Temperature Controlled Warehouse Facility Modification 1 (SSD-8586218-Mod-1)
Request for Additional Information

I refer to the recent lodgement of the modification application for the Temperature Controlled Warehouse Facility (SSD-8586218-Mod-1). After careful consideration, the Department is requesting that you provide additional information.

INDUSTRIAL DEVELOPMENT
LOT 4, BRINGELLY ROAD, LEPPINGTON, SYDNEY

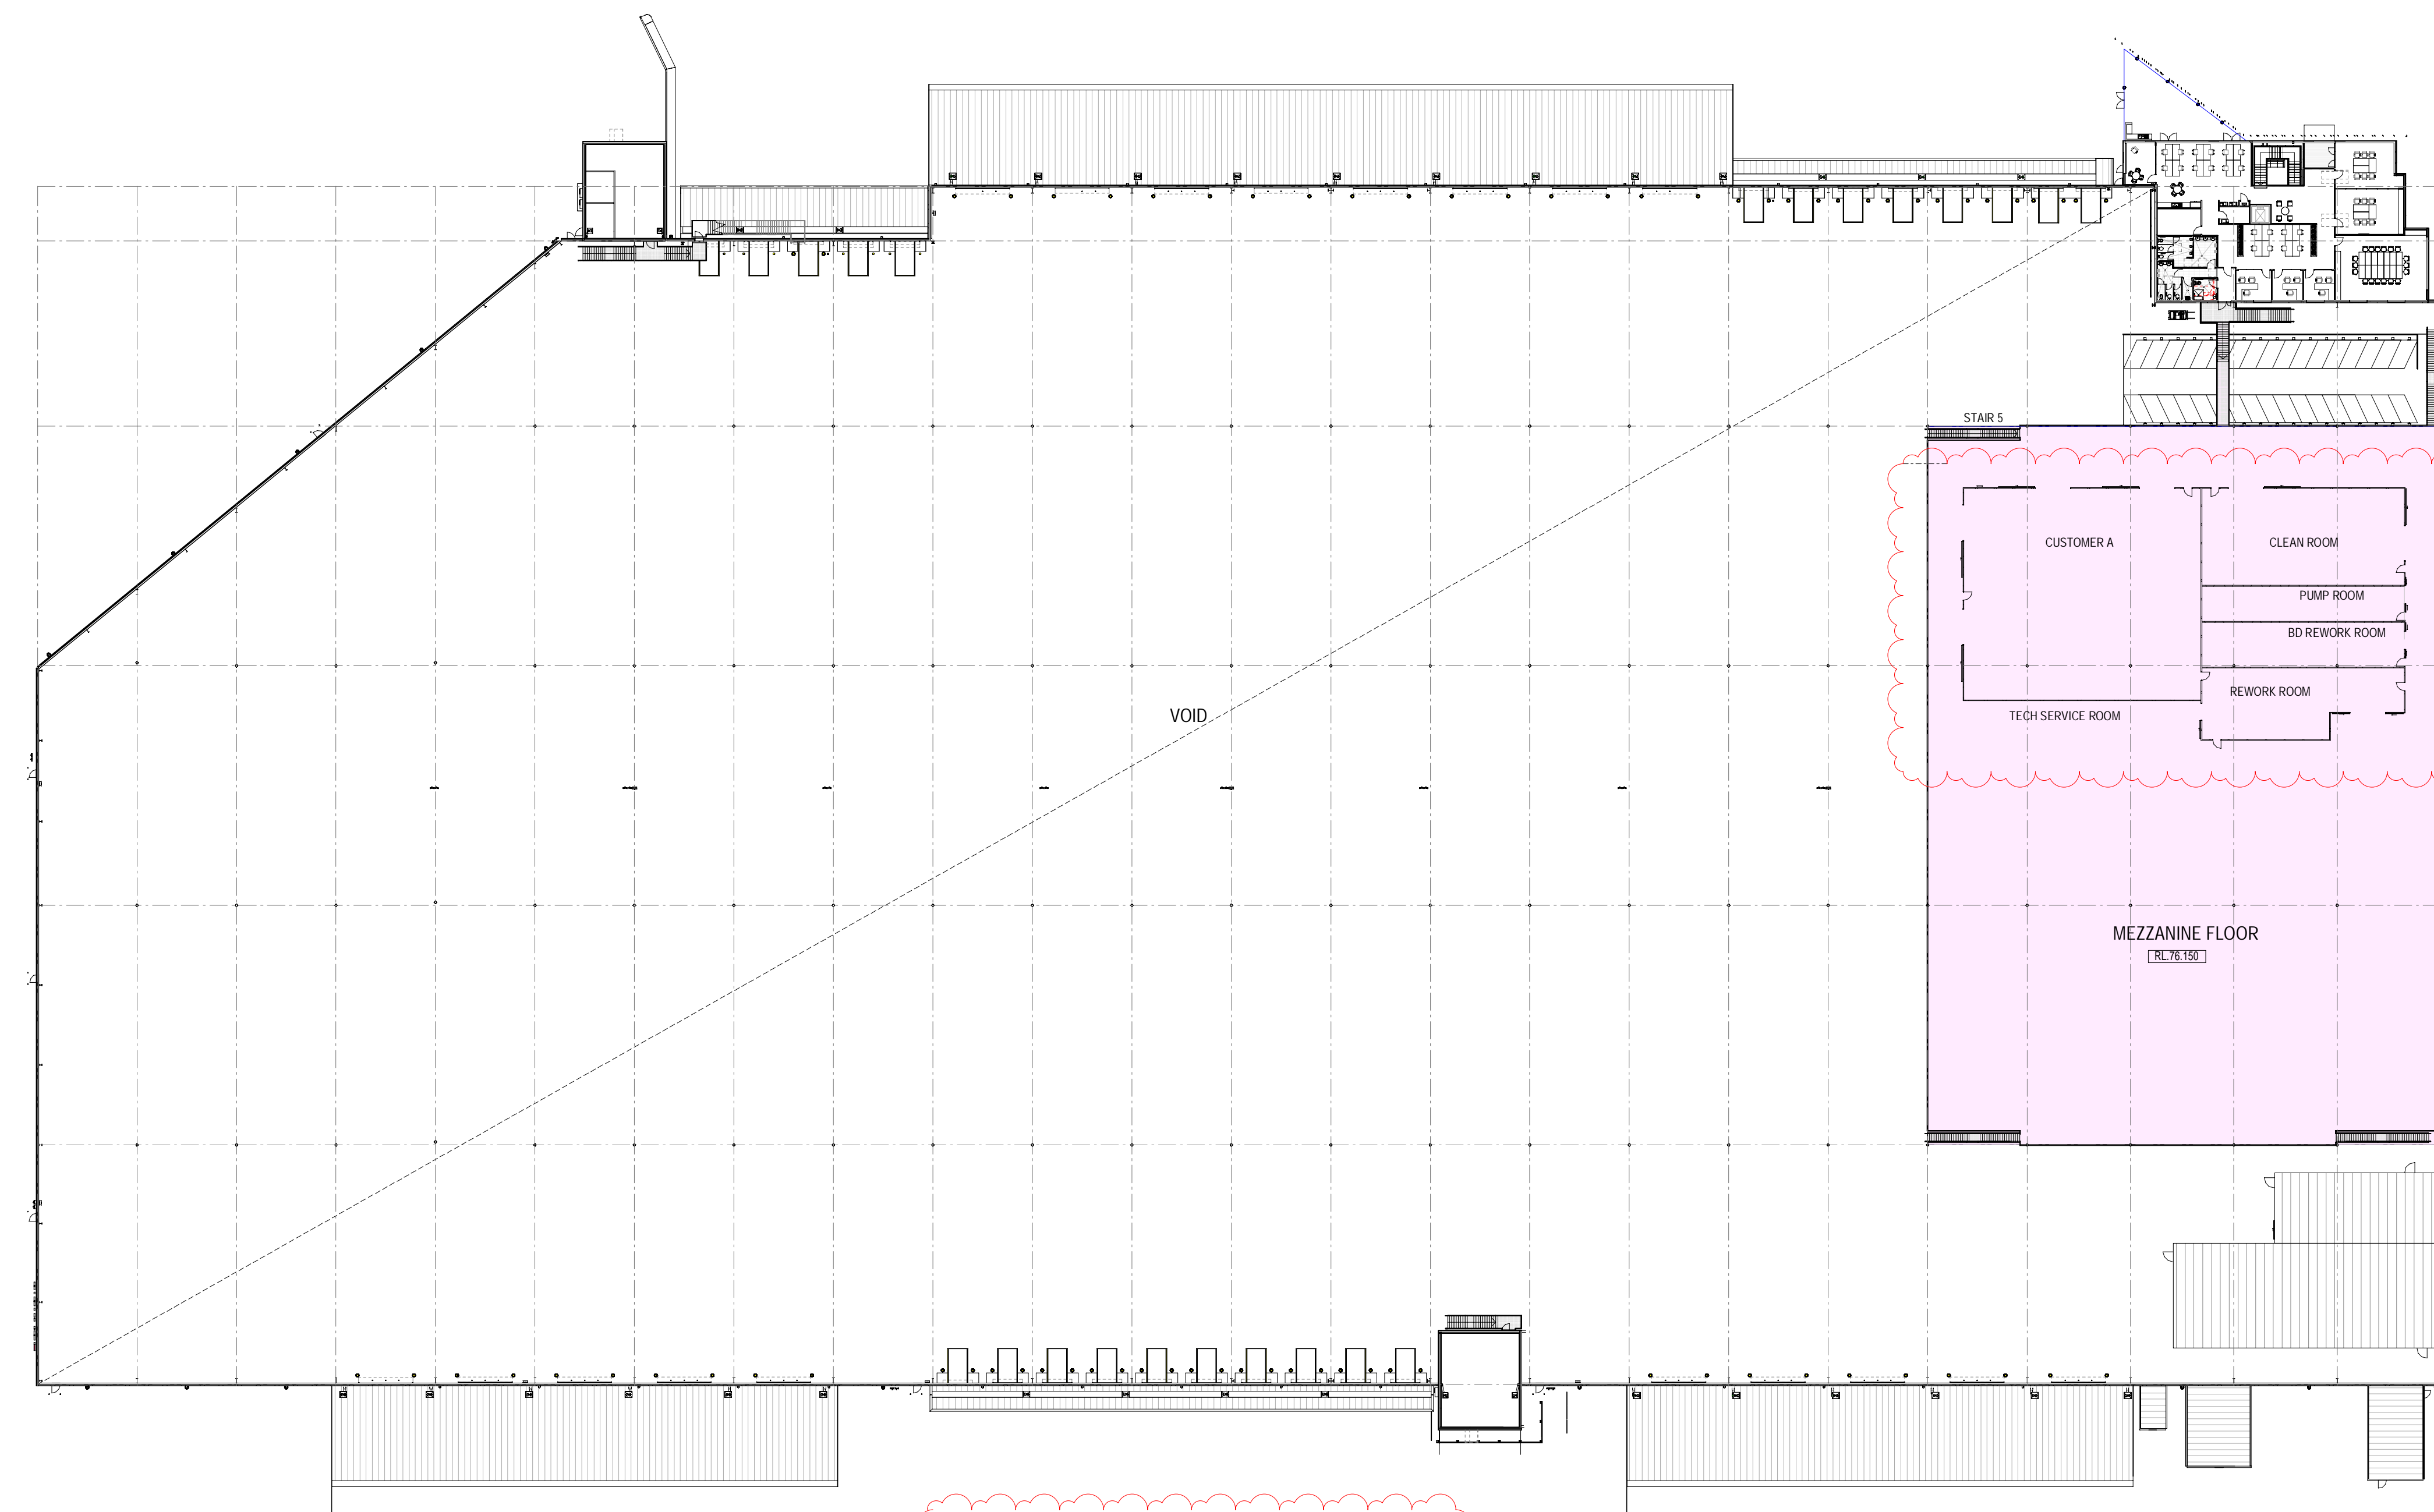
1. Section 2.1.1 of the supplied report notes that several rooms on the mezzanine floor will be used to process, service and repair goods, which may be considered an industrial activity. The Department considers the information provided in the modification application report to be insufficient to understand the exact activities proposed and how this aligns with the use of the development, as consented to. Further details on this aspect of the modification must be provided, including:

- (i) the exact processes and activities that are proposed to be carried out, including good's entry and exit from the facility and their relation to the use of the site as a warehouse. Details should also be provided on any additional impacts these processes may have, including waste or additional staffing levels

- (ii) further justification as to how the additional industrial activities can be considered as substantially the same development to the existing consent for a warehouse facility.
